Consultee Comment for planning application 24/00539/F

Application Number	24/00539/F
Location	Land To The East Of Stratfield Brake And West Of Oxford Parkway Railway Station Oxford Road Kidlington
Proposal	Erection of a stadium (Use Class F2) with flexible commercial and community facilities and uses including for conferences, exhibitions, education, and other events, club shop, public restaurant, bar, health and wellbeing facility/clinic, and gym (Use Class E/Sui Generis), hotel (Use Class C1), external concourse/fan-zone, car and cycle parking, access and highway works, utilities, public realm, landscaping and all associated and ancillary works and structures
Case Officer	Laura Bell
Organisation	Drainage (CDC)
Name	Tony Brummell
Address	Cherwell District Council Bodicote House White Post Road Bodicote Banbury OX15 4AA
Type of Comment	Comment
Type	
Comments	<ol style="list-style-type: none">Flood Risk<p>It is agreed that there is no material flood risk on the site from any source save for a small area of surface water flood risk which can be mitigated within the site infrastructure design. Therefore, I have no objections in principle to the development on flood risk grounds.</p>Su

Figure 14.2 - Existing Drainage Ditches

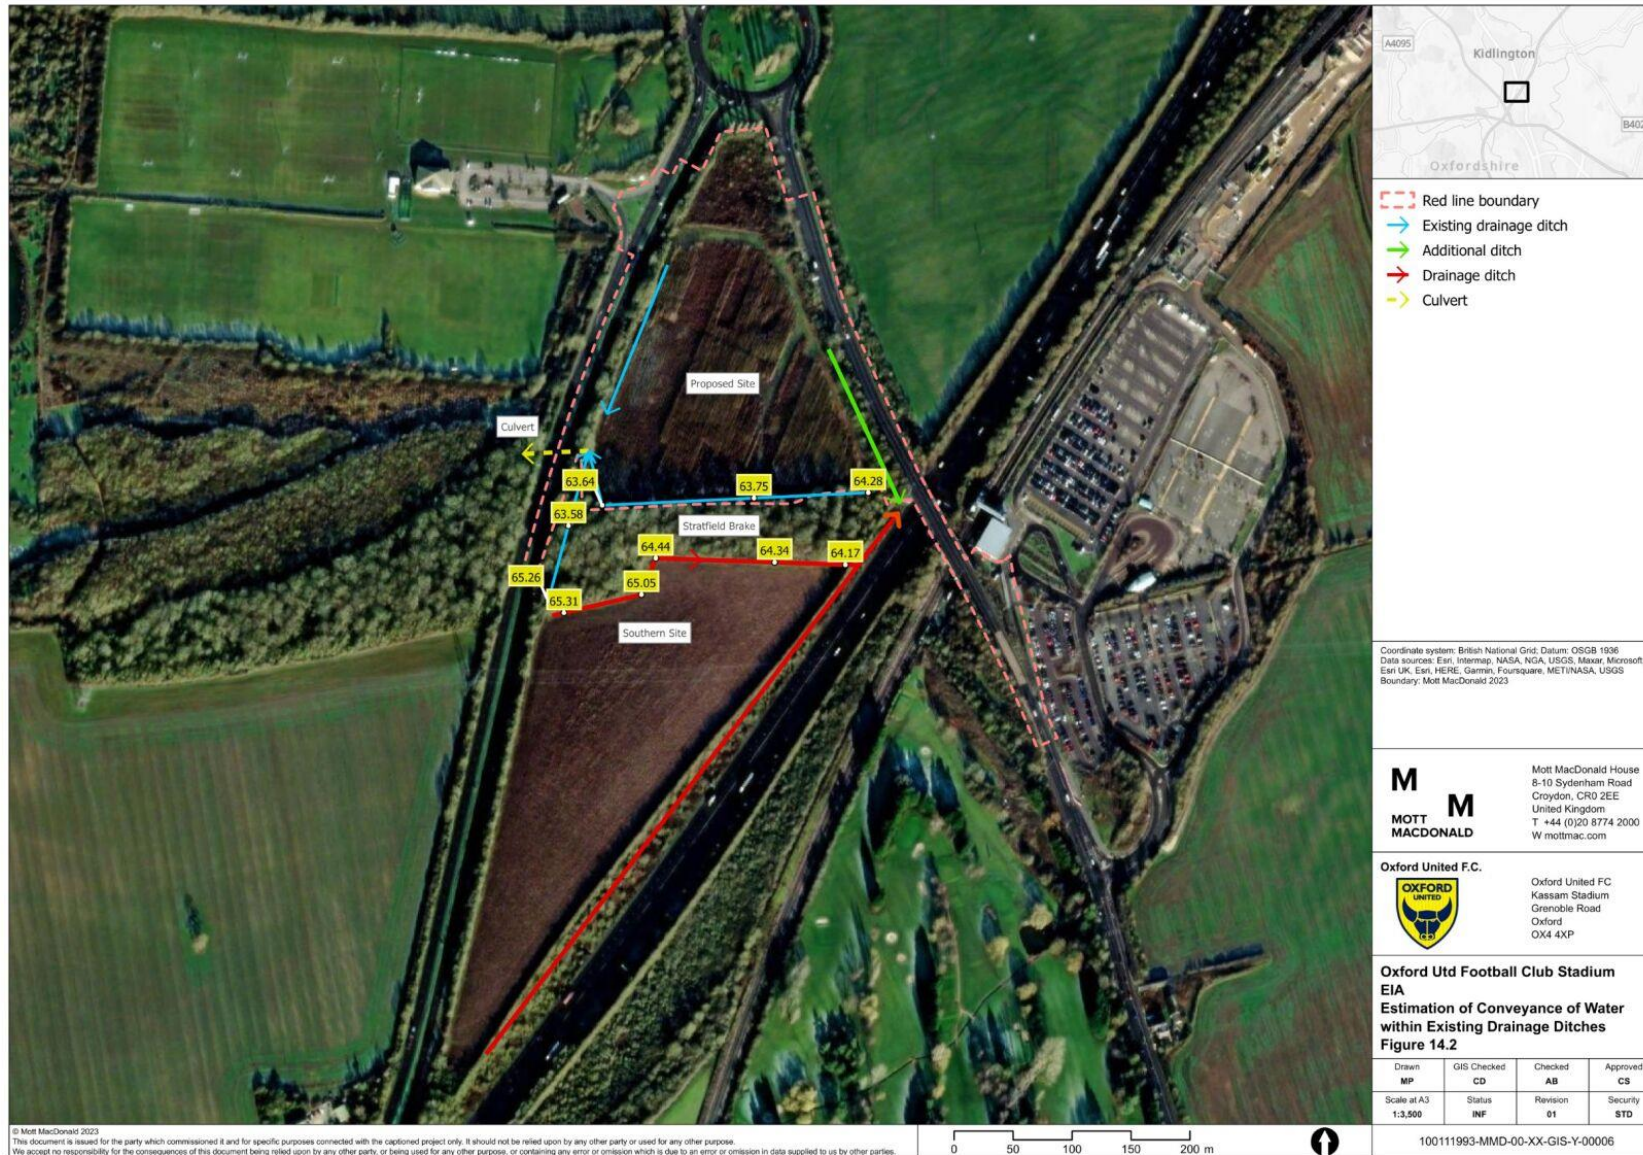
(vii) Further investigations are required on how the highway systems in both the A4260 and A4165 are drained. Any inflows through or onto the development site and through the A4260 culvert must be fully understood and accommodated within the site infrastructure.
